From: Carrillo, Abiel X.
To: ["Yolanda Padilla Moyer"](#)
Cc: [Biazar, Shahab](#)
Subject: ROFG - Del Webb Phase I @ Mirehaven - H019D017C
Date: Friday, August 26, 2016 2:07:00 PM
Attachments: [Mirehaven Del Webb 1 ROFG Comments.pdf](#)

Based on the information provided in your Certification dated 7-6-2016, and a field visit of the completed improvements, the following comments will need to be addressed before we approve the submittal for Release of Financial Guarantee:

CITY PROJECT NO. ZONE MAP NO. SHEET 2 OF 8

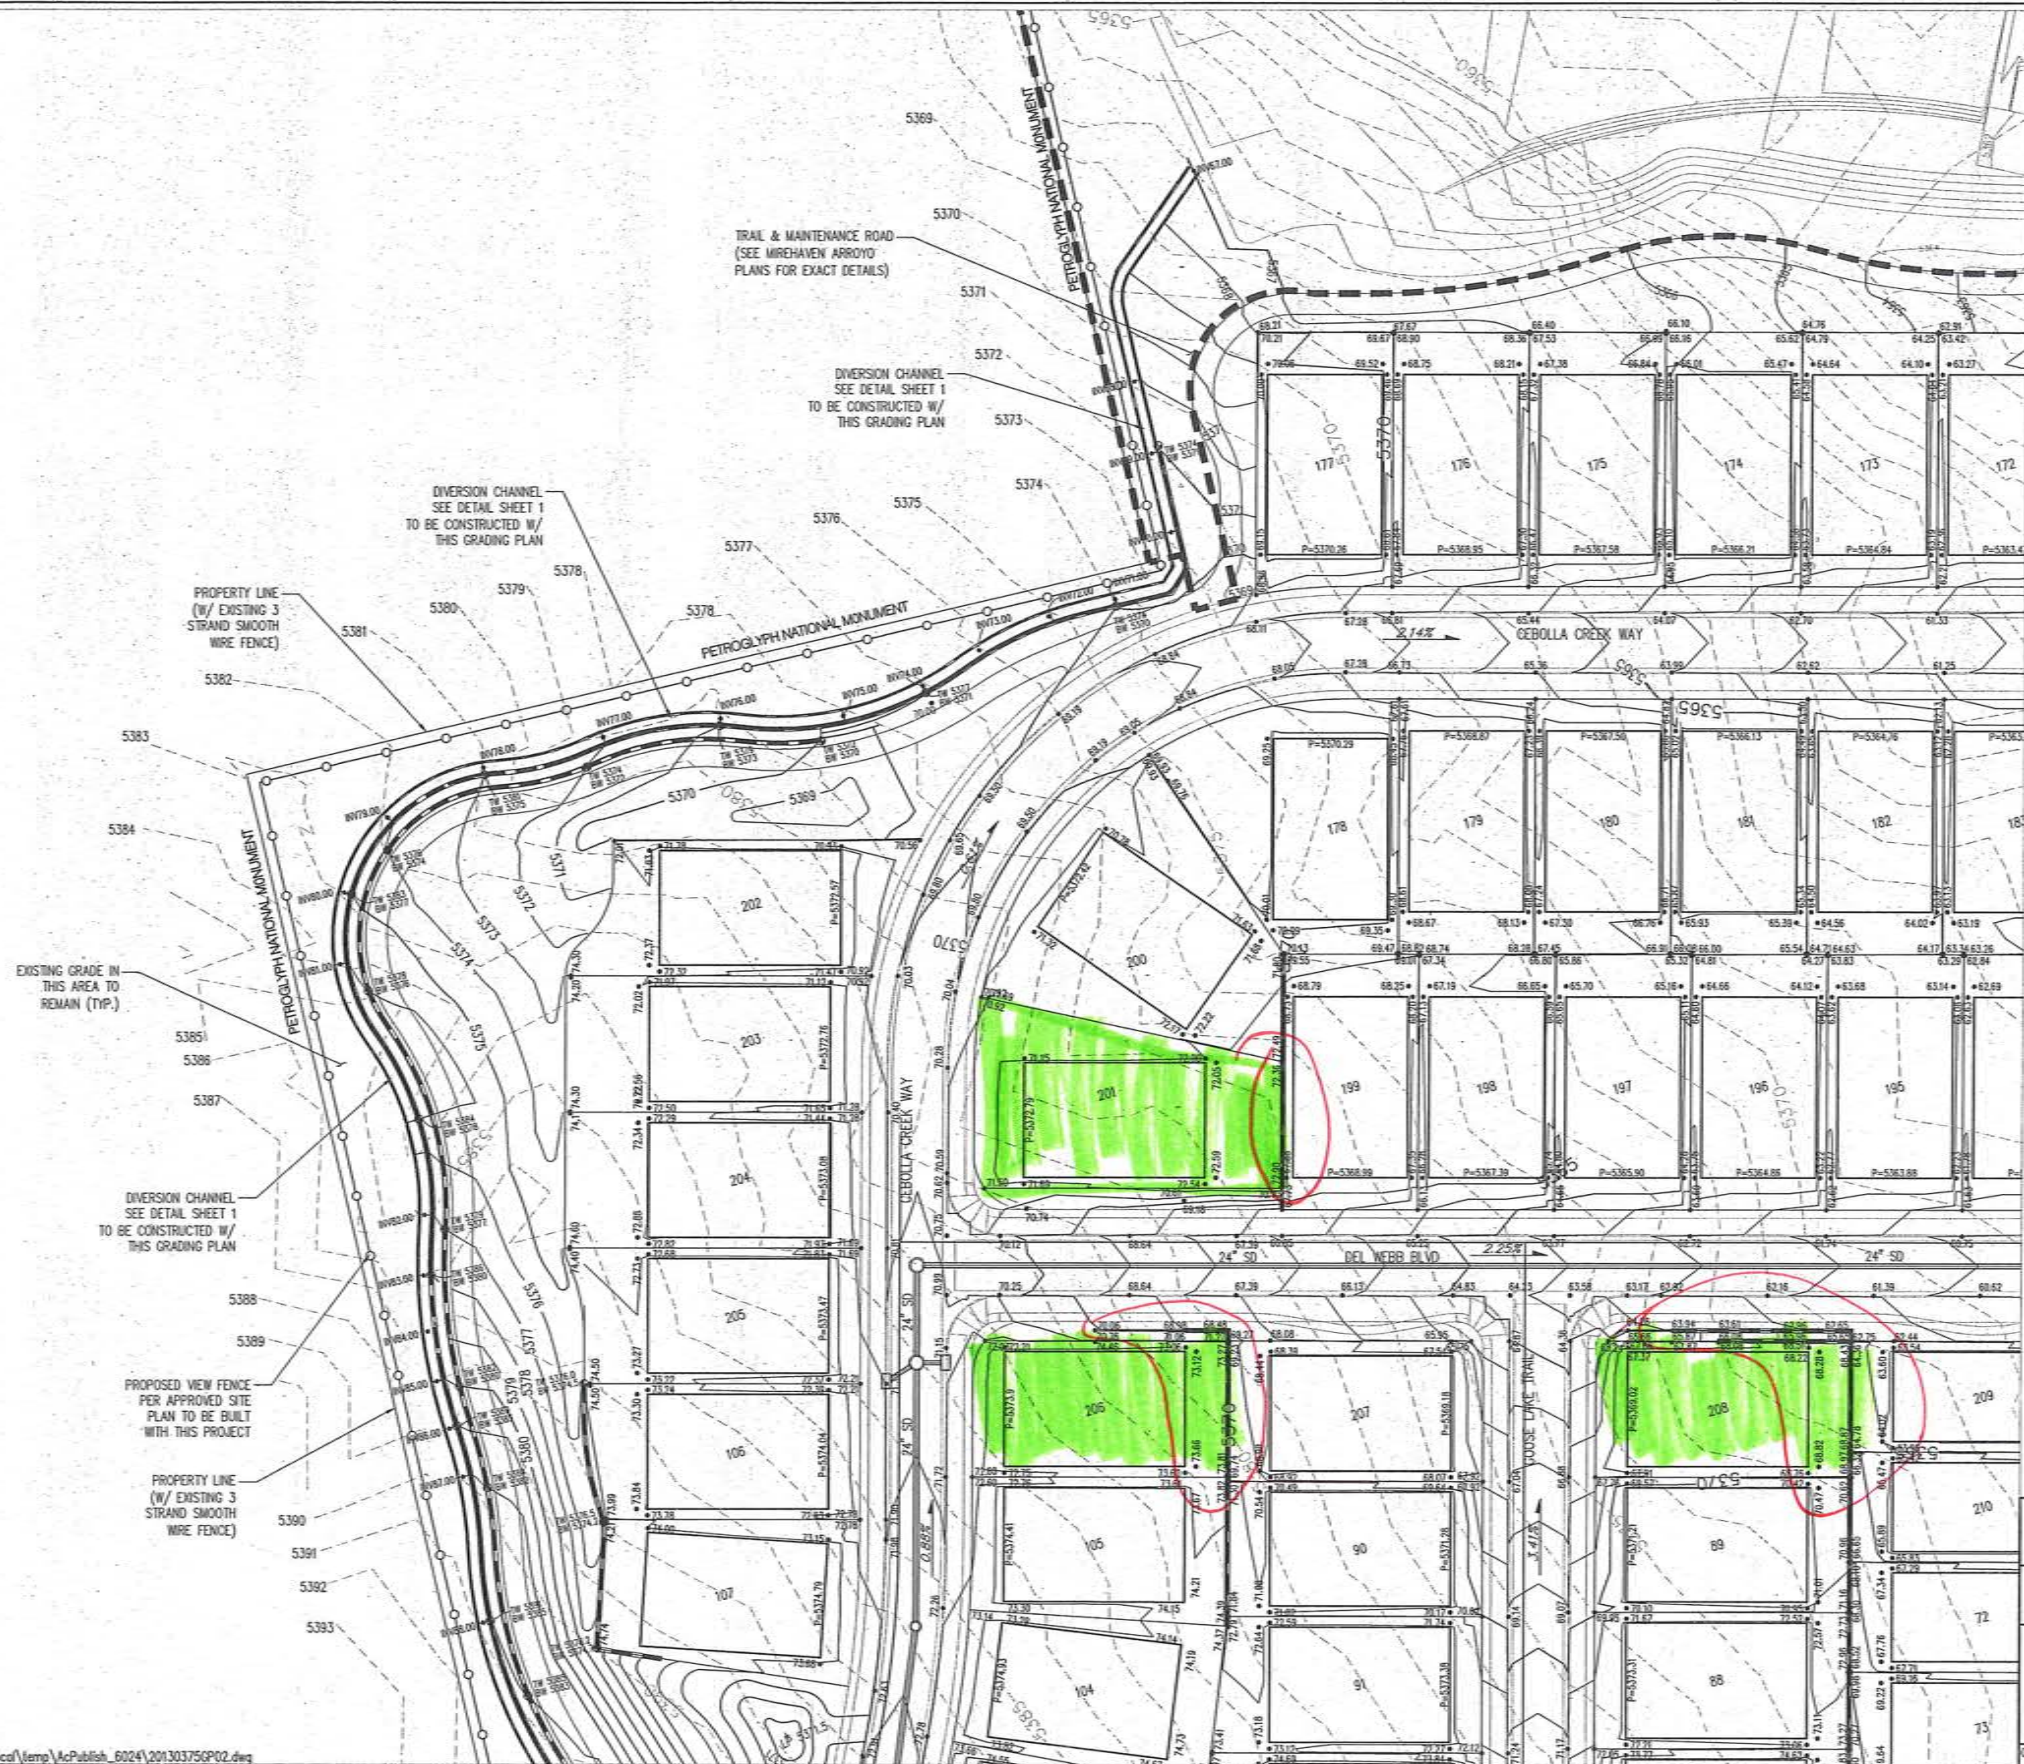
2. Sheet 2B shows a change to the approved plans which re-directs the diversion channel onto the pedestrian trail/sidewalk connection behind lots 172 through 177. It is not acceptable to discharge the channel directly onto the pedestrian trail. It is clear that the intent for the colored concrete segment was to provide a pedestrian connection. As a corrective measure, a swale could be constructed behind the wall of the concrete pedestrian path and connect to the Arroyo (may not need to be shotcrete/concrete if the energy can be dissipated).

3. At the same location as the previous comment, the widened concrete transitions behind Lot 177 to a shotcrete-like surface with a pedestrian sidewalk aligned on center. The sidewalk/access then extends into the arroyo at-grade and terminates on the northern bank. To my knowledge there is no authorization for such a crossing.

5. A portion of the wall shown with a heavy solid lineweight on Sheet 2A, between the retaining wall and the beginning of the swale was not constructed. It appears that the slope may not need a wall. However, additional stormwater is now entering the subdivision, which would have otherwise been redirected to the diversion channel. Is the impact negligible?

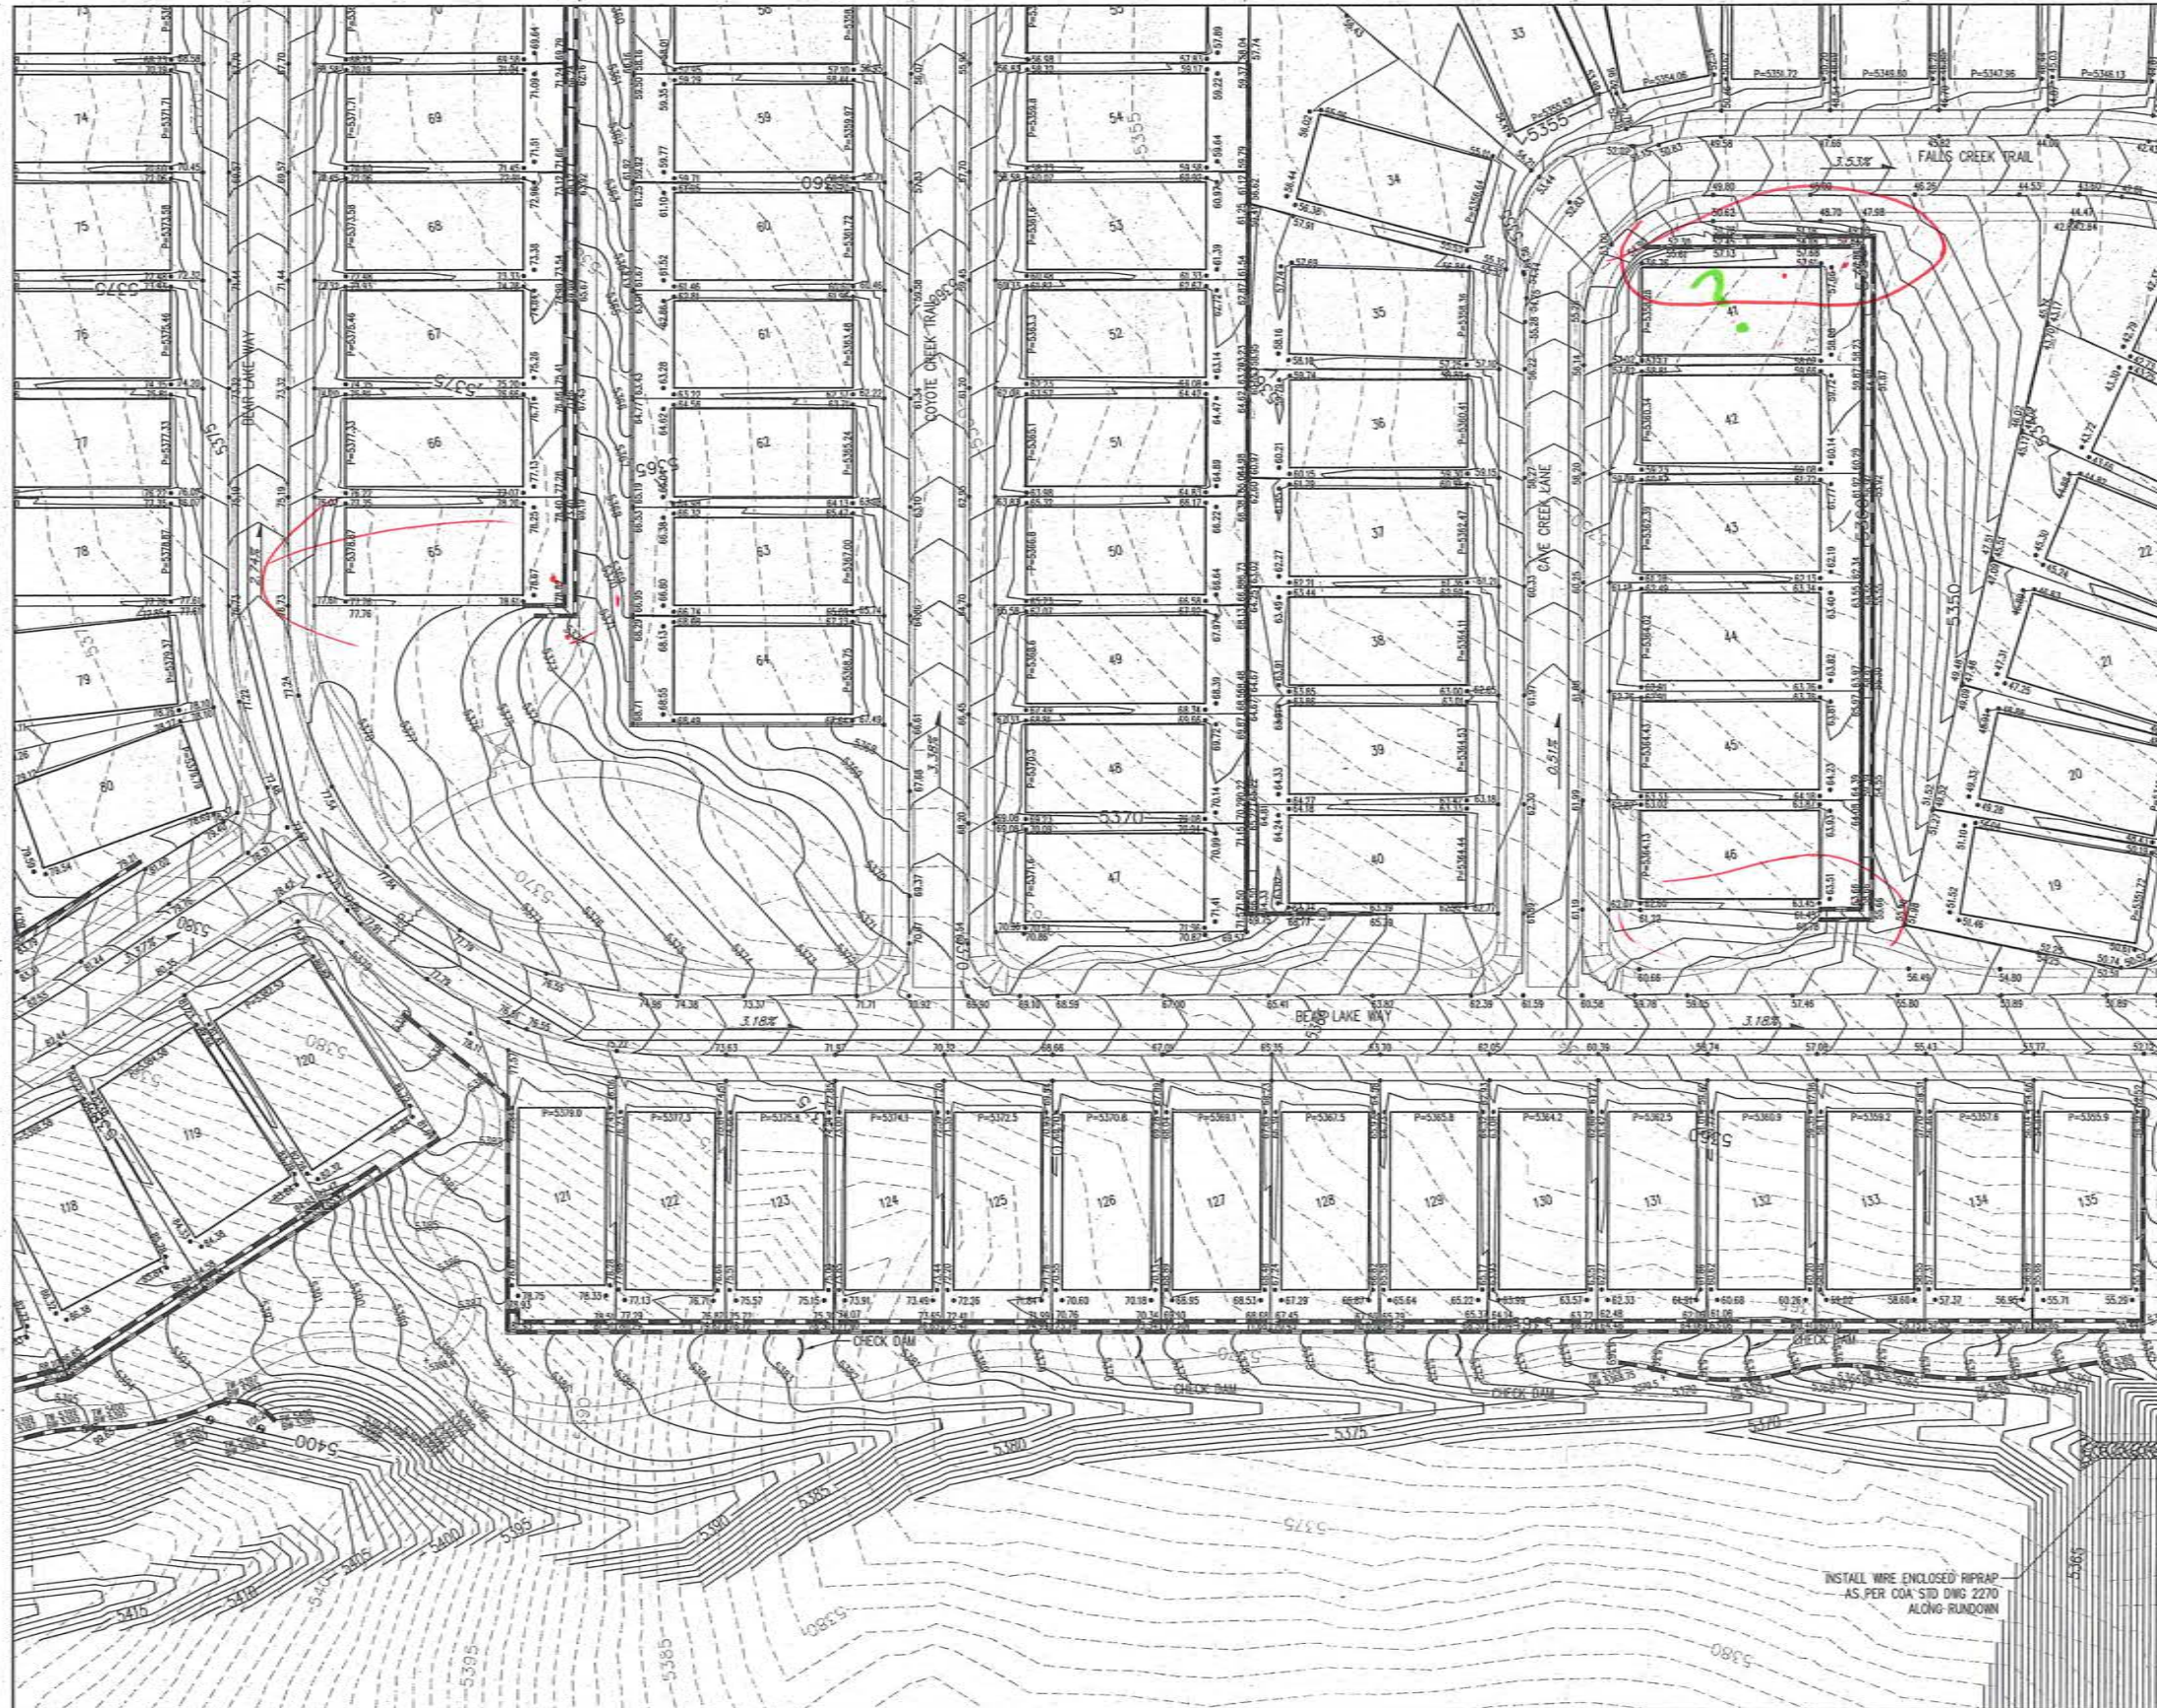
7. Sheet 6 shows an inflow channel and rip rap swale for the large temporary pond. A silt fence is placed perpendicular to the flow into the pond. It should be removed and the channel should be shaped to allow unobstructed flow into the pond. The berm that is forming is redirecting sediment onto the trail and behind lot 135-Bear Lake Way.
8. Additional erosion control is needed beyond the existing rip rap over the steep slope behind Lots 120 and 121-Bear Lake Way.
9. There is edge cracking along the asphalt trail behind Lots 130-135-Bear Lake Way, possibly due to erosion of the trailside surface.
10. The tie slope between the pond and Mirehaven Parkway is missing the rock mulch called out on the plans (Sheet 7).
